WELWYN HATFIELD COUNCIL – DEVELOPMENT CONTROL
DELEGATED REPORT

APPLICATION No:	S6/2010/265/FP
------------------------	-----------------------

The application seeks full planning permission for an extension to the existing care home, which has 38 beds, to provide accommodation for a further 22 rooms (purpose built accommodation and care facilities for people suffering from dementia), reconfiguration of car parking and amenity space.

DRAWING TITLE:
 PROPOSED PLANS

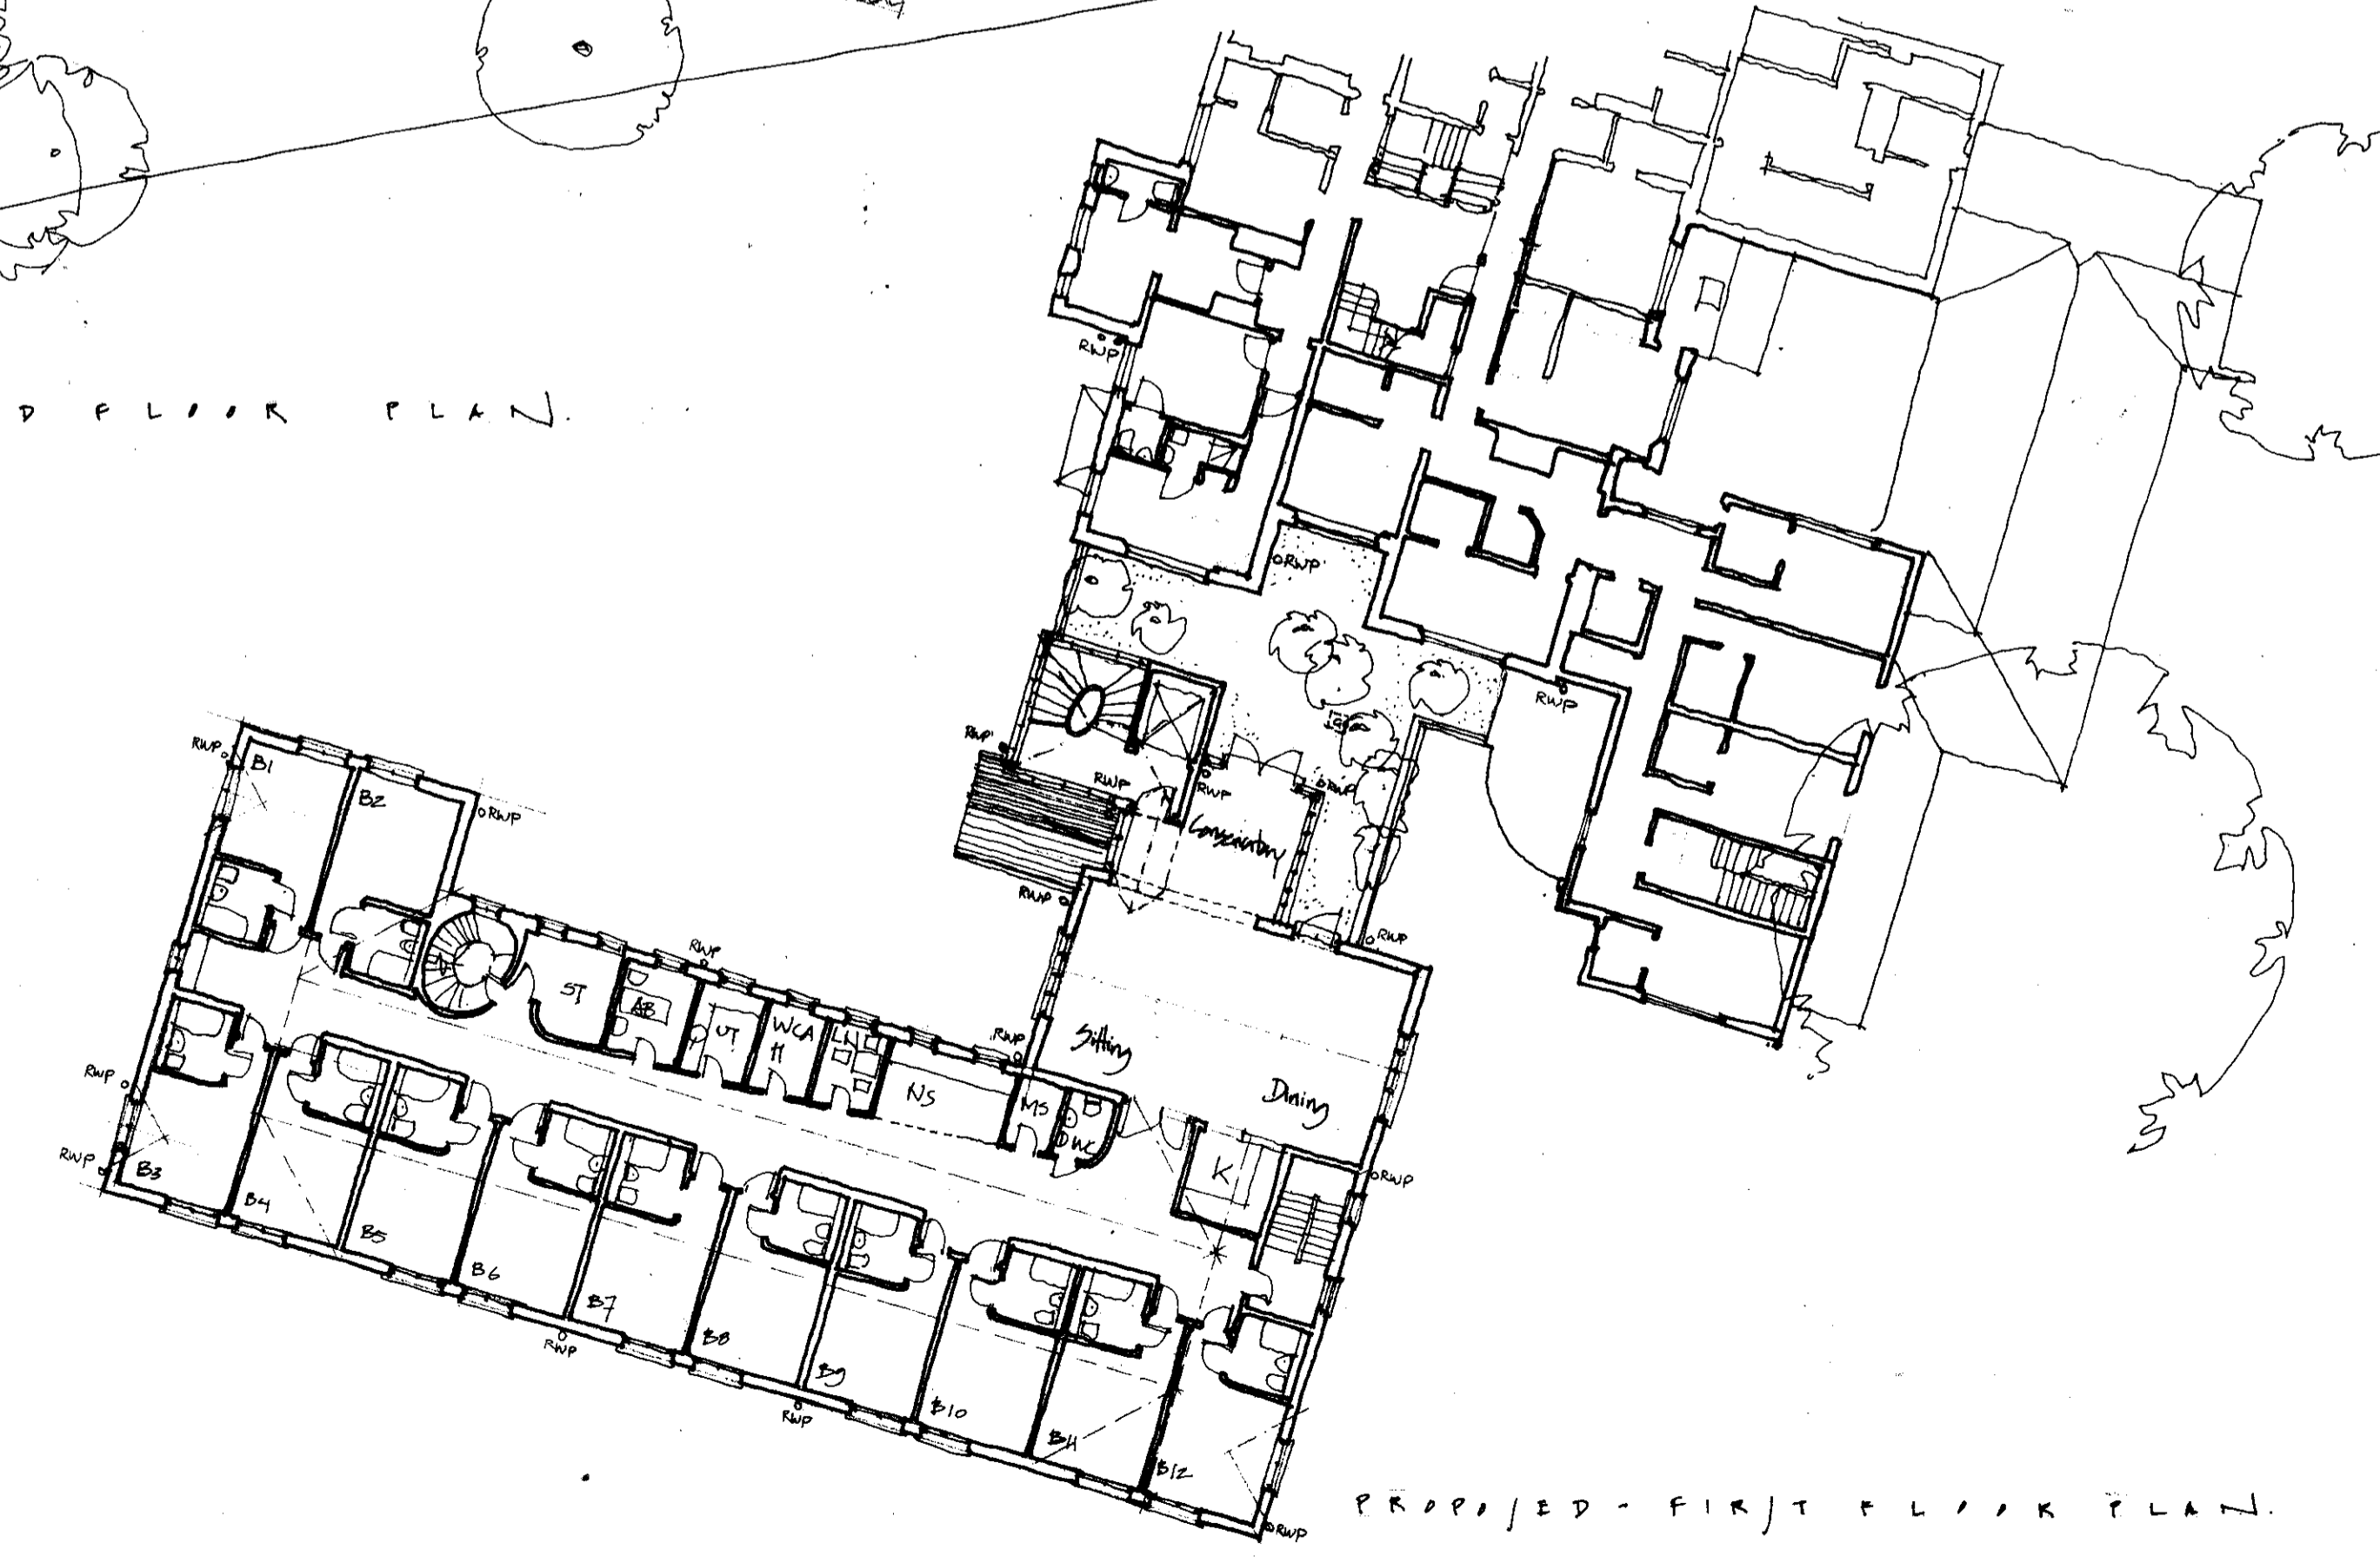
Welwyn Hatfield Access Group have queried the use of the lift and where refuges are to be located.

Welwyn Hatfield Access Group have queried with the agent's emergency egress facilities. The agents have advised that the lift would be a combined fire-fighting and evacuation lift, with an area annotated conservatory on drawing number 759/002A for people with mobility difficulties to be accommodated whilst awaiting the fire brigade.
